Assington Parish Council

Response to the Examining Authority's First Written Questions (ExQ1) for Bramford to Twinstead (EN020002)

Map 9 - Local Green Spaces

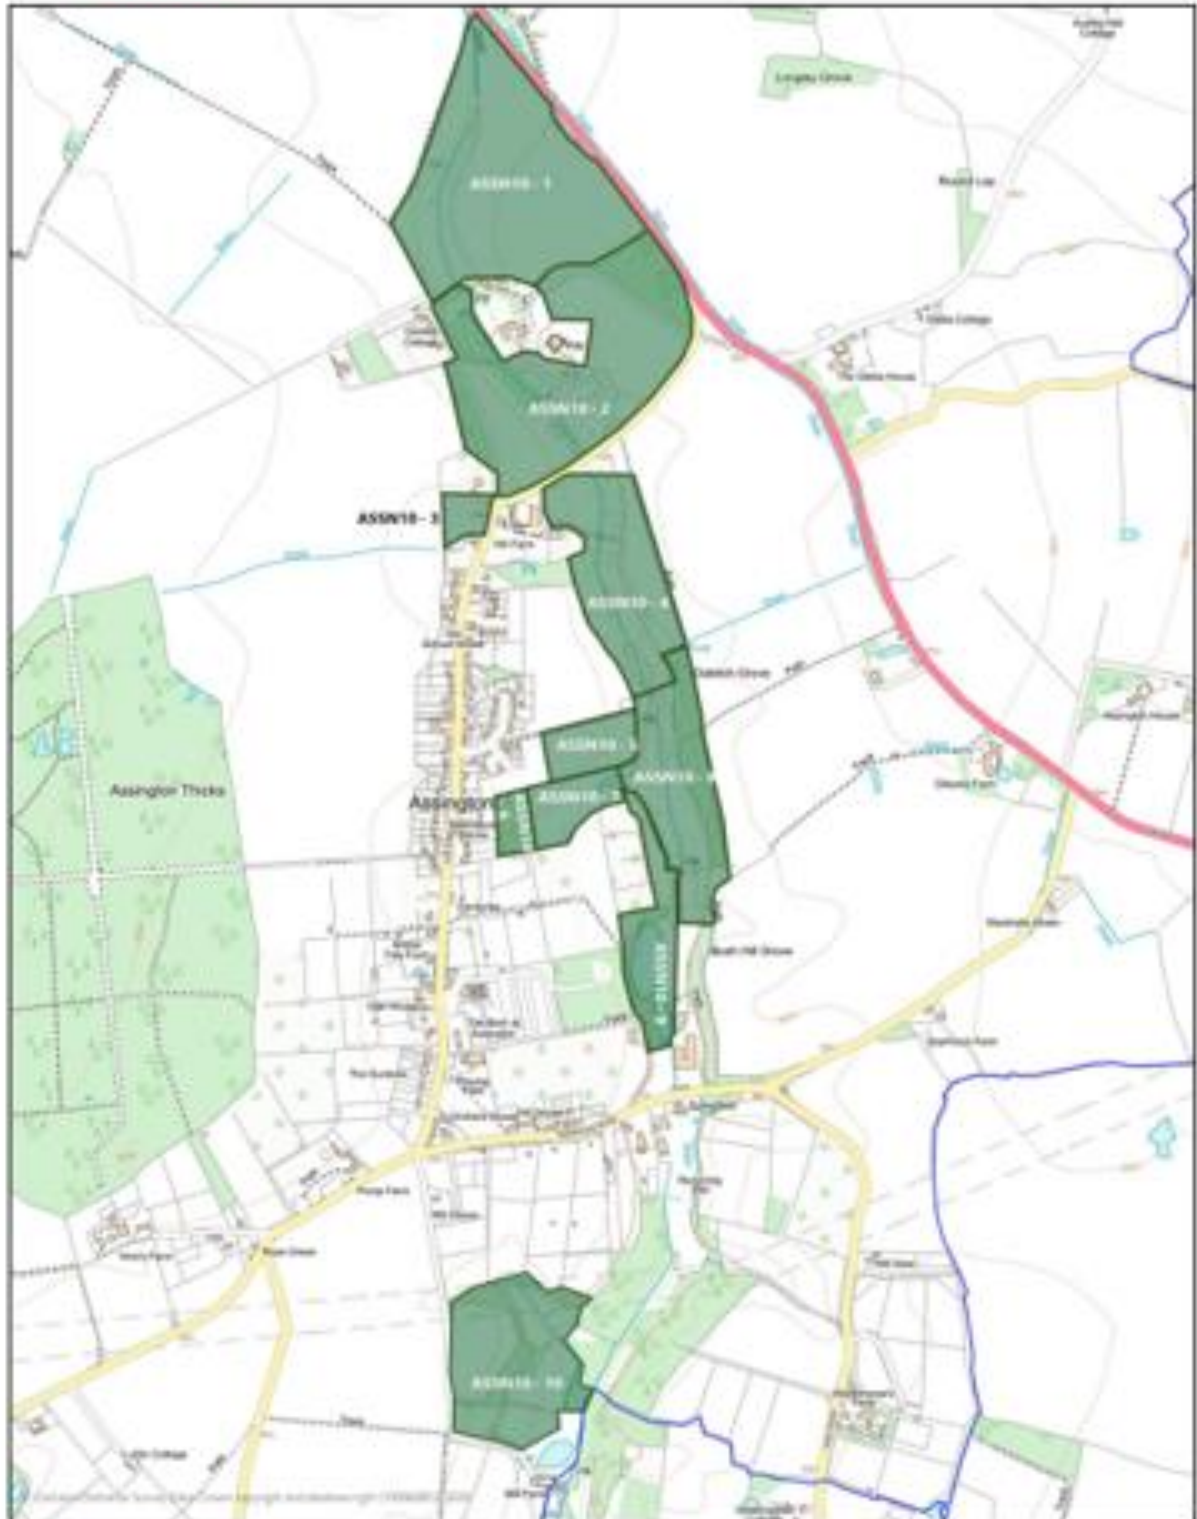
6. The proposed development in these Local Green Spaces is deeper into the Green Space than UK Power Networks' existing 132kV line, and the proposed infrastructure is larger and considerably taller than the existing pylon. The proposal will therefore inevitably harm local residents' enjoyment of the Green Space

7. The proposed access route would also create a break in the mature hedge line that is a feature of the Green Space
8. In summary, by proposing new building in the Green Belt, and because of the permanent harm that it will cause to these Local Green Spaces, the proposed development is contrary to the requirements of the National Planning Policy Framework, and should therefore not be considered compatible with policy ASSN-10
